From: [REDACTED]
To: [Great Yarmouth Third River Crossing](#)
Cc: [REDACTED]
Subject: Great Yarmouth Third River Crossing - response to ExA's written questions (Deadline 2) [BDB-BDB1.FID9979150]
Date: 22 October 2019 17:53:52
Attachments: [REDACTED]

GYPA

Examining Authority written questions and requests for information (ExQ1)

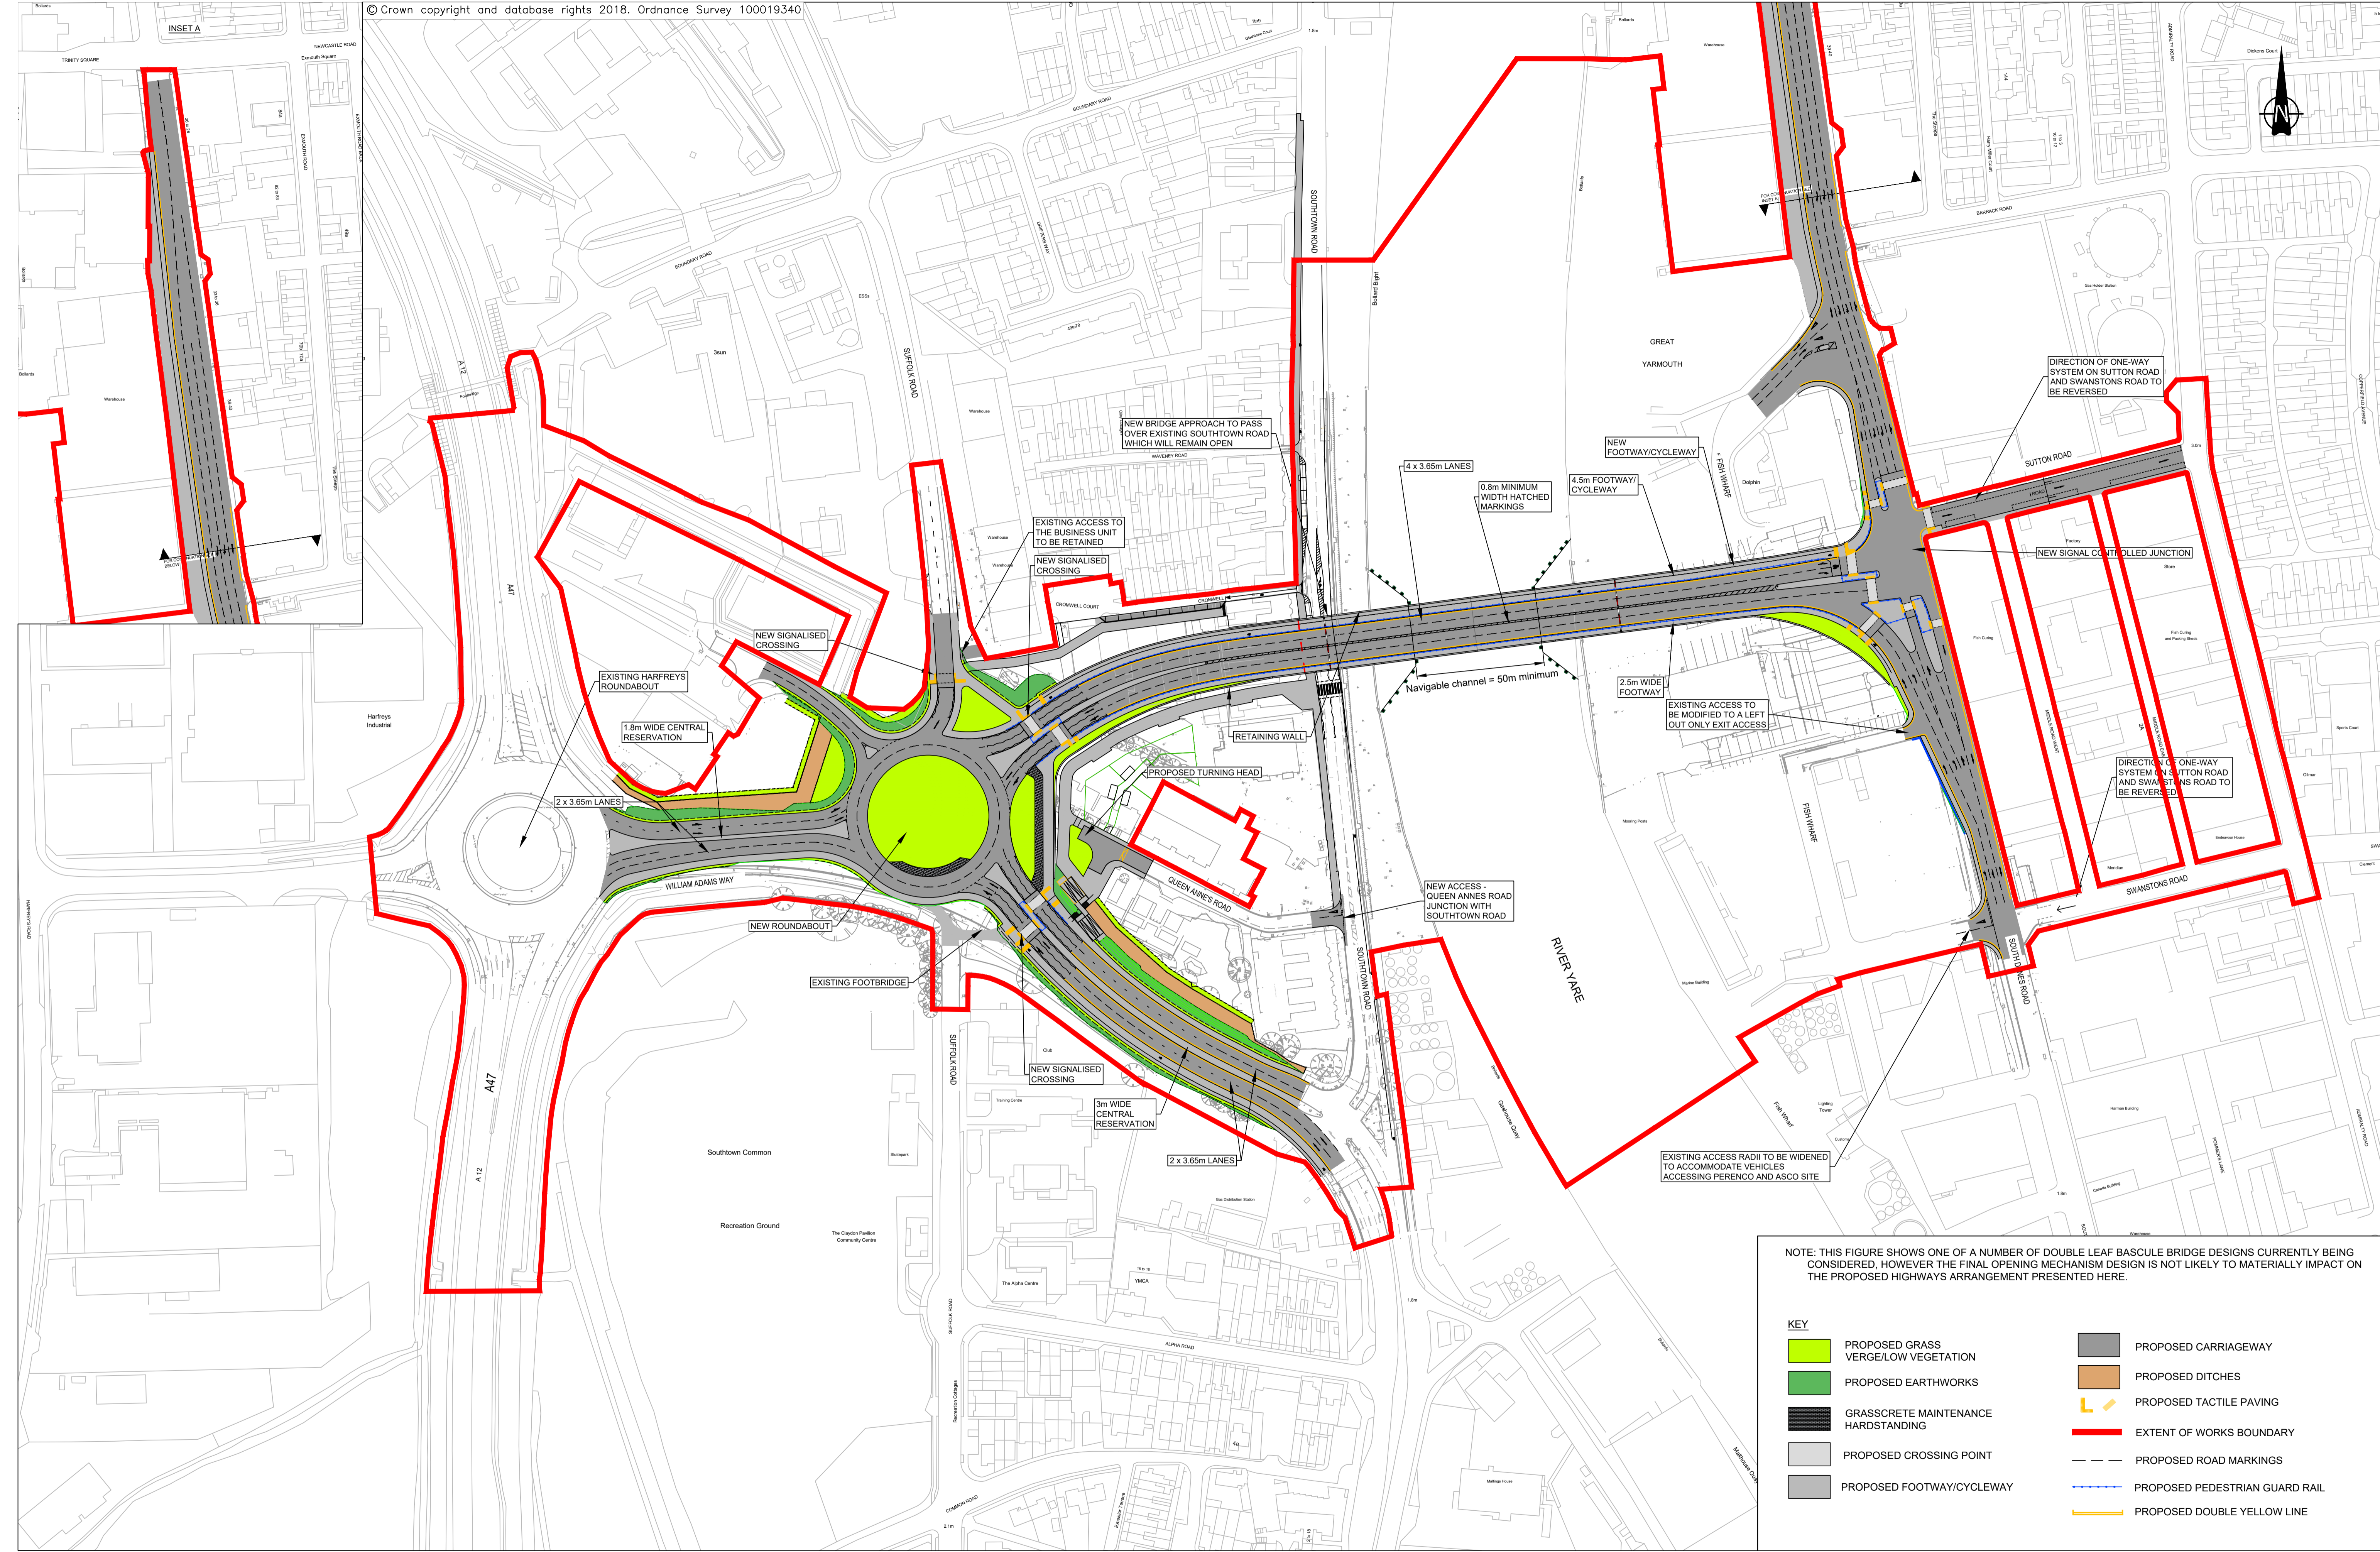
1.0.10	<p>Leisure vessels the waiting areas proposed and shown in the General Arrangements are suitable for this category of craft.</p> <p>However, neither of the proposed locations are adequate to meet the safe mooring requirement of a commercial vessel needing to transit the bridge (due to factors including but not limited to a very close proximity to the bridge and the size/design of these facilities safely to moor a large Vessel.</p> <p>Outbound Vessels would remain adequately secured to the Quay until the bridge is confirmed fully open, before proceeding on passage. This fully mitigates the safety risk to the Vessel of bridge failure to open, however it is likely that this process would require the bridge to be open for an appreciable period (potentially up to twenty-five minutes each time, in GYPA's considered view) in order to allow outbound vessels to transit through.</p> <p>Inbound Commercial Vessels: Once the vessel has entered the inner harbour, there is no designated/available place for the vessel safely to be berthed if, for whatever reason, the bridge does not open. The Vessel becomes exposed to wind and tide (including a reducing depth of water) and is severely compromised in her ability safely to manoeuvre (including insufficient room to turn).</p> <p>Mitigations considered included</p> <ol style="list-style-type: none"> a) opening the bridge before the Vessel enters the Inner Harbour. This would require the bridge is open for a period likely to cause significant disruption to road traffic (30 mins +) and to occur at time coinciding with maximum demand (Rush hours).The Harbour Authority would require the power unilaterally to decide when the bridge must open and expect no challenge. b) providing a designated Emergency Layby Berth that the Vessel's Passage Plan identifies as a contingency for failure to open. Such berth should be located, based on Pilots' advice, to the south of the proposed crossing. The Length, Depth and Bollards etc at such berth require to be adequate, safely to moor a Commercial vessel of type presently using the port and

<p>at all states of Tide. GYPA is able and supportive to advise the Applicant accordingly.</p> <p>Safety of navigation will be compromised by any failure of the bridge to open as expected. Consequences for the affected Vessel absent adequate contingency, include but are not limited to collision (with another vessel and/or bridge) and/or grounding with consequential pollution.</p> <p>GYPA strongly recommends that an emergency lay-by berth should be provided for commercial shipping. This option will shorten the time required for the bridge to remain open.</p> <p>The NRA considered the risk of bridge failure to open and the effect of this factor on Vessels under way in the Inner Harbour but the report has only recently been made available for review by the Harbour Authority.</p>

1.8.9	<p>GYPA will require to consult with Leisure/recreational vessel stakeholders. It is envisaged Leisure vessels will rely on the facilities indicated on the General Arrangement. The waiting facility will reduce the frequency of bridge openings. It is expected that during the bridge open period, leisure vessel(s) may pass before or after a commercial vessel, subject to communication protocols (to be developed).</p>
